Subject: Rezoning Petition Review

Rezoning Petition #: 21-241

Location of Property: Approximately 1.85 acres located at the southeast intersection of Sardony Ln and E WT Harris Blvd, north of Rocky River Rd.

DRAWING NO: **SP-1**

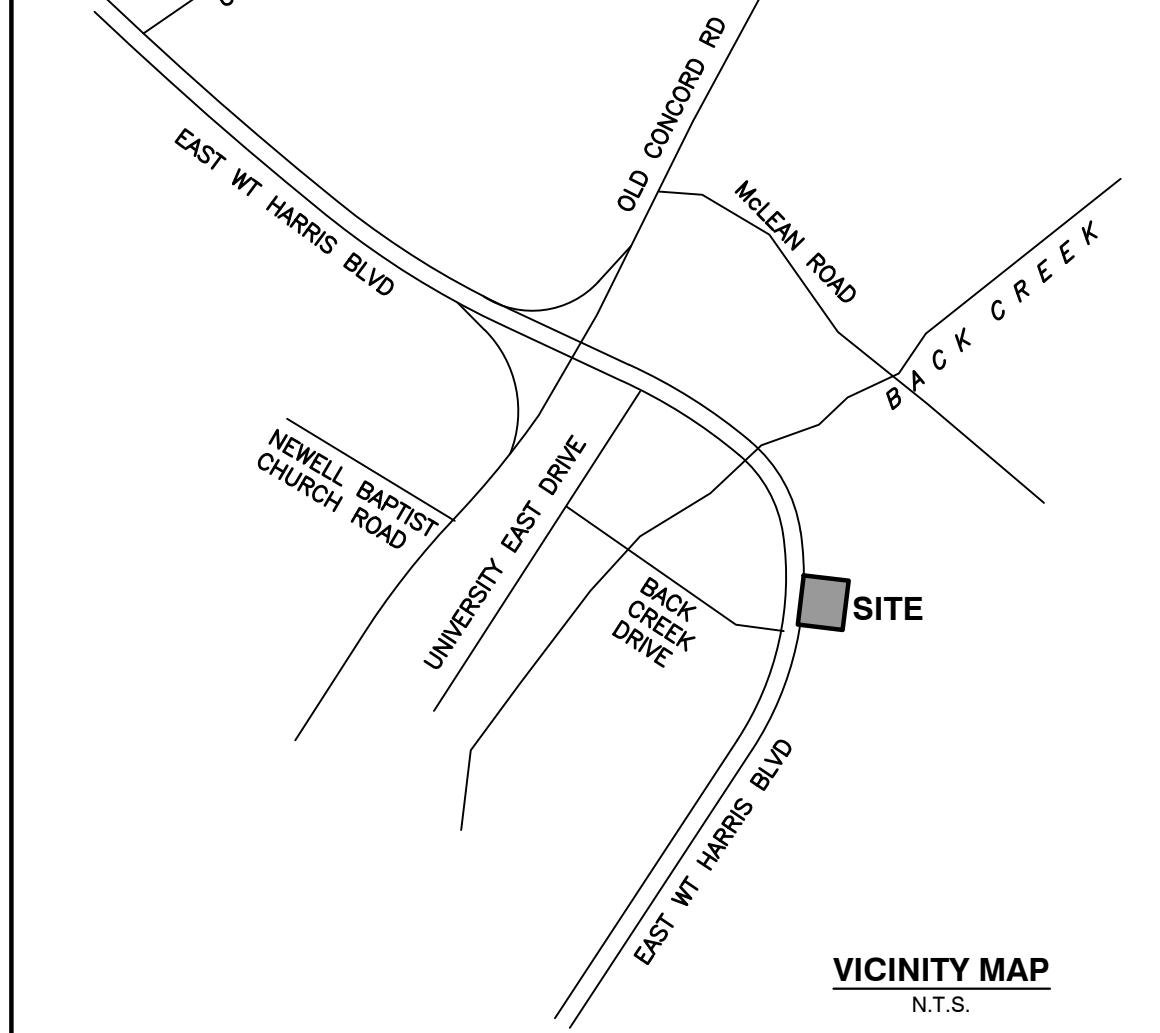
City of Charlotte GIS indicates a 50-ft Undisturbed PCSO Buffer across the site. Please show and label "Potential 50-ft Undisturbed PCSO Buffer" on the site plan. Any increase of impervious area within such buffers may not be allowed and is not approved with the rezoning process. Please include the following note under Environmental Features: *"Development within any SWIM/PCSO Buffer shall be coordinated with and subject to approval by Charlotte-Mecklenburg Storm Water Services and mitigated if required by City ordinance. Petitioner acknowledges intermittent/perennial stream delineation reports are subject to review and approval upon submission of development plans for permitting and are not approved with rezoning decisions."*
